DEPARTMENT OF PUBLIC WORKS

MEMORANDUM

TO: Jeff Watson, Community Development Services
FROM: Christina Wollman, Planner II *CW*
DATE: August 21, 2012
SUBJECT: Neversweat Land SG-12-00004

The Public Works Department has reviewed the Request for Parcel Segregation Application. In order to ensure that it meets current Kittitas County Road Standards, the applicant needs to provide the following prior to final approval:

**K.C.C. 16.08.015
ADMINISTRATIVE
SEGREGATIONS
FOR**

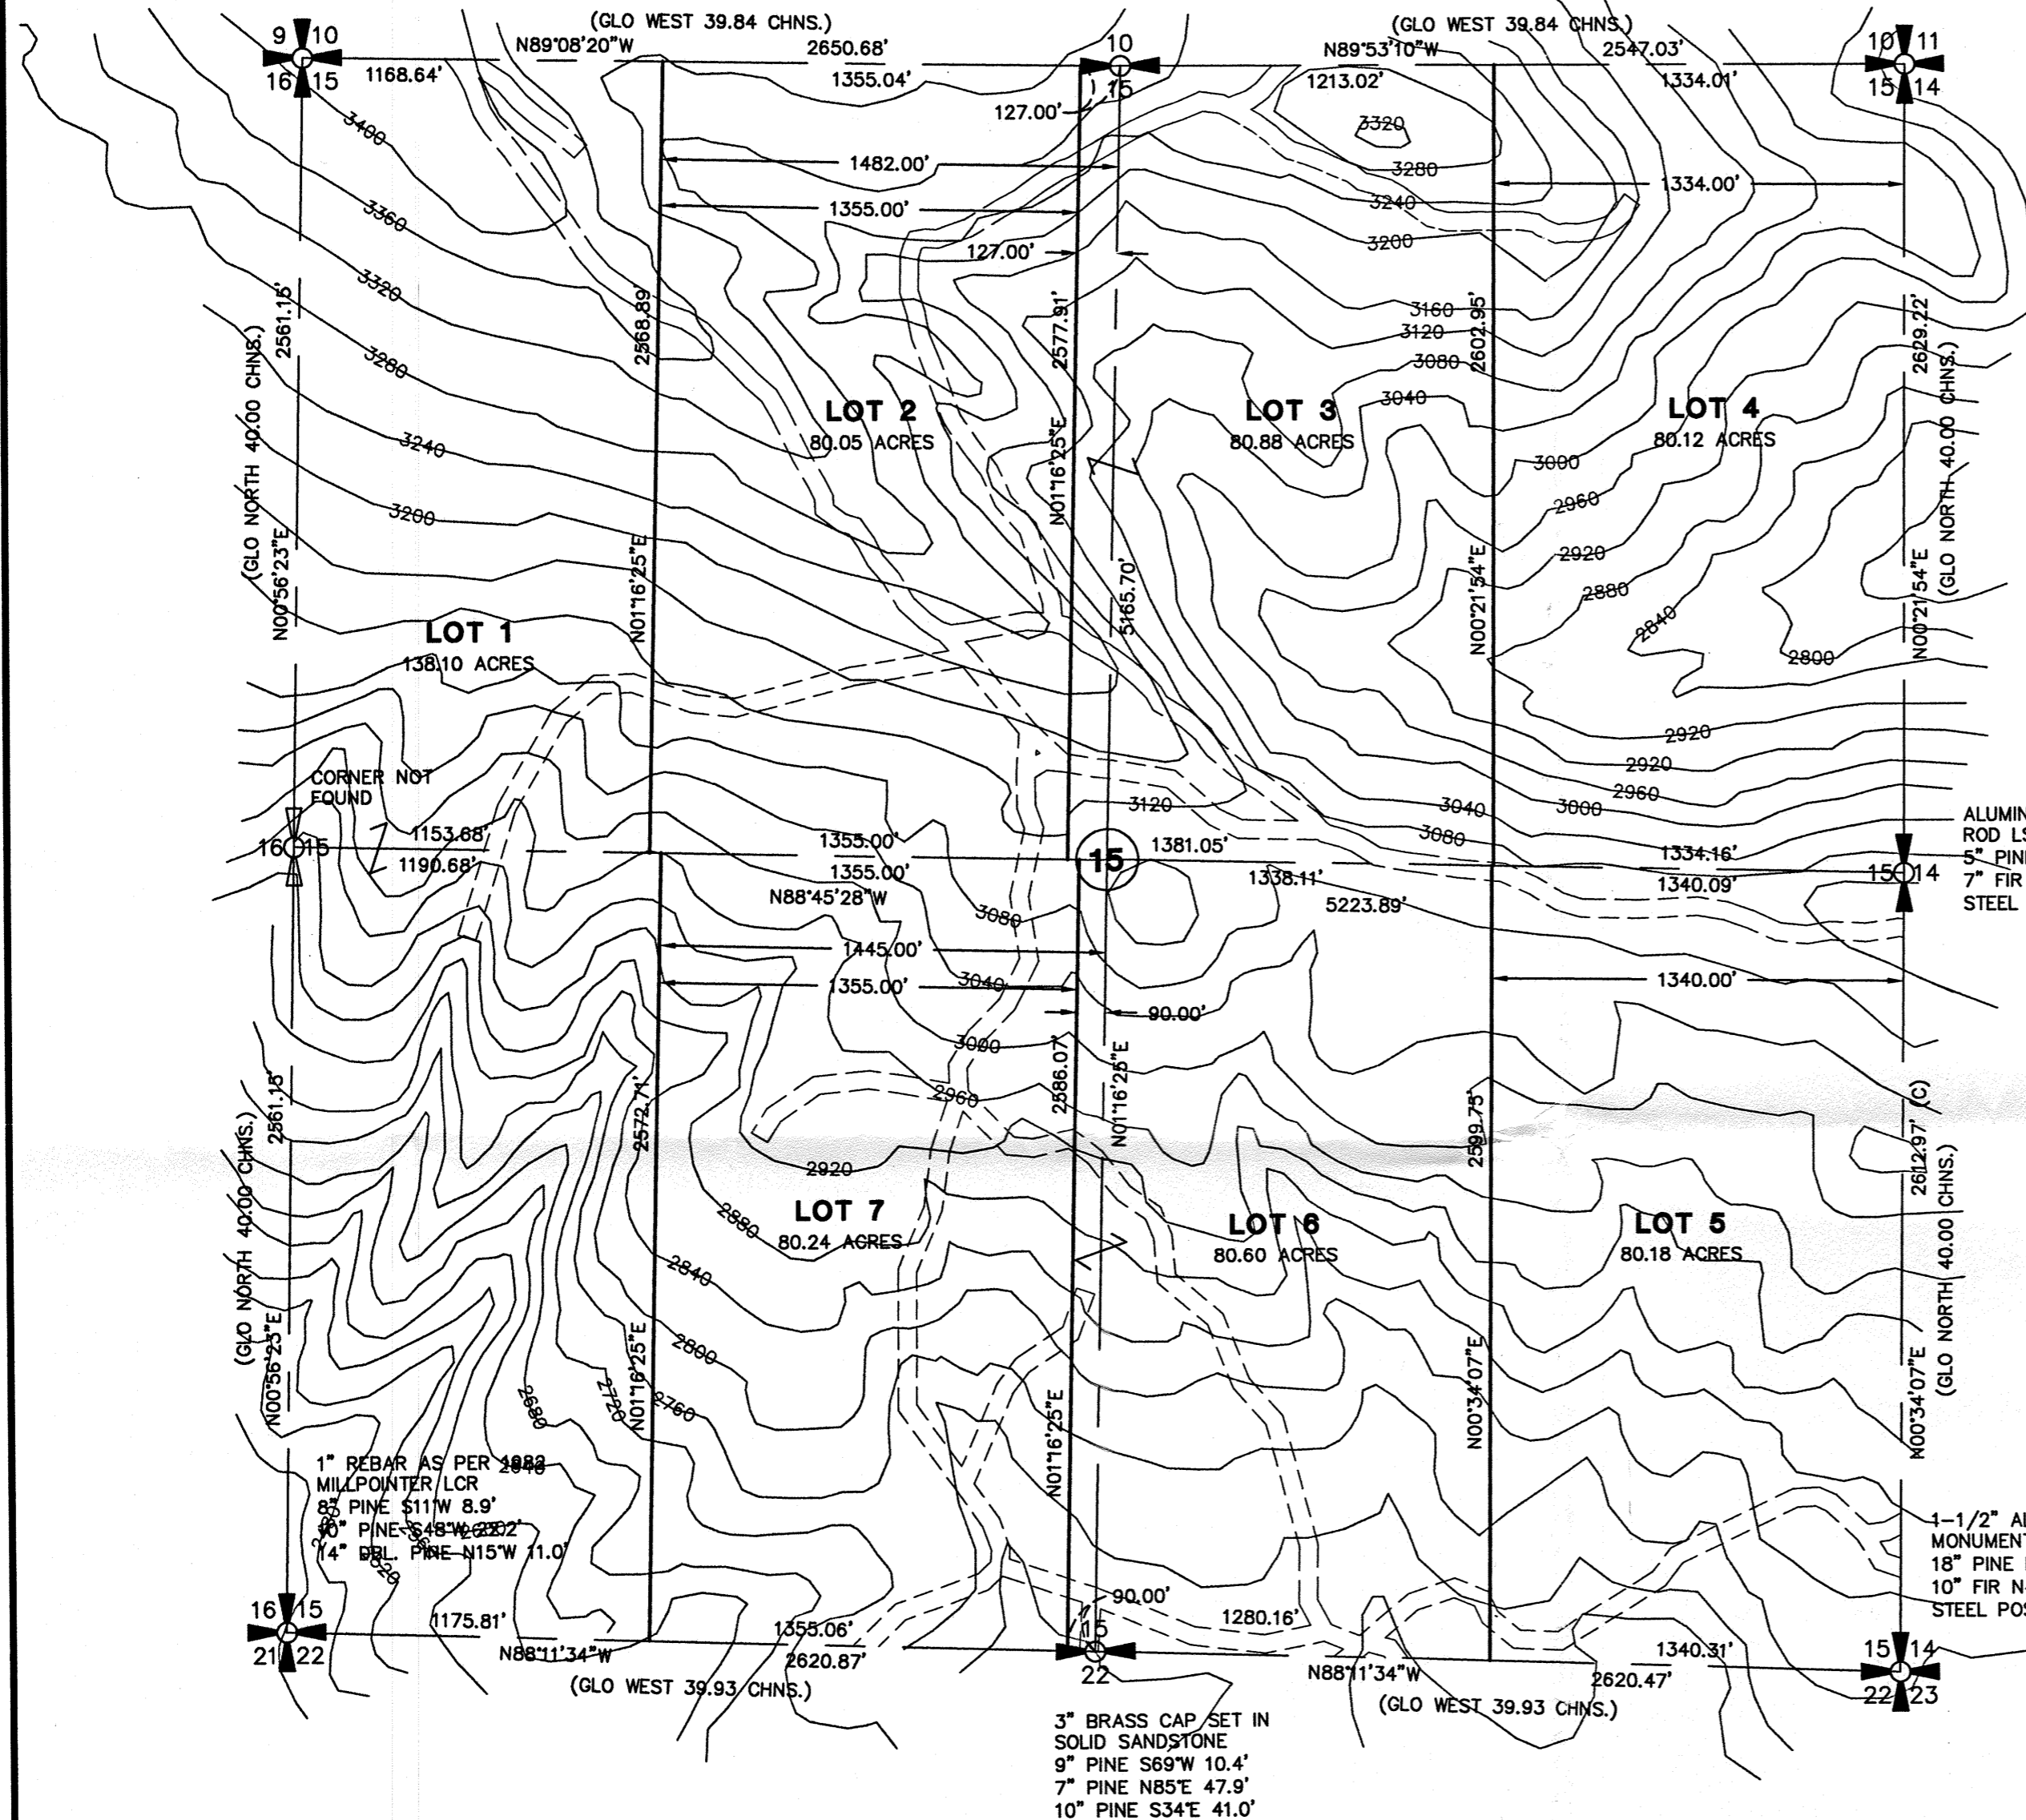
1. The applicant shall contact the City of Cle Elum to determine if any improvements are required on the portion of private road within the recently expanded city limits. Please provide documentation of this conversation prior to final approval.
2. Easements for cul-de-sacs shall be shown on the final survey where road improvements are expected to end if the property is developed in the future. Please contact me if you would like to confirm those locations meet road standards requirements prior to recording the final survey.
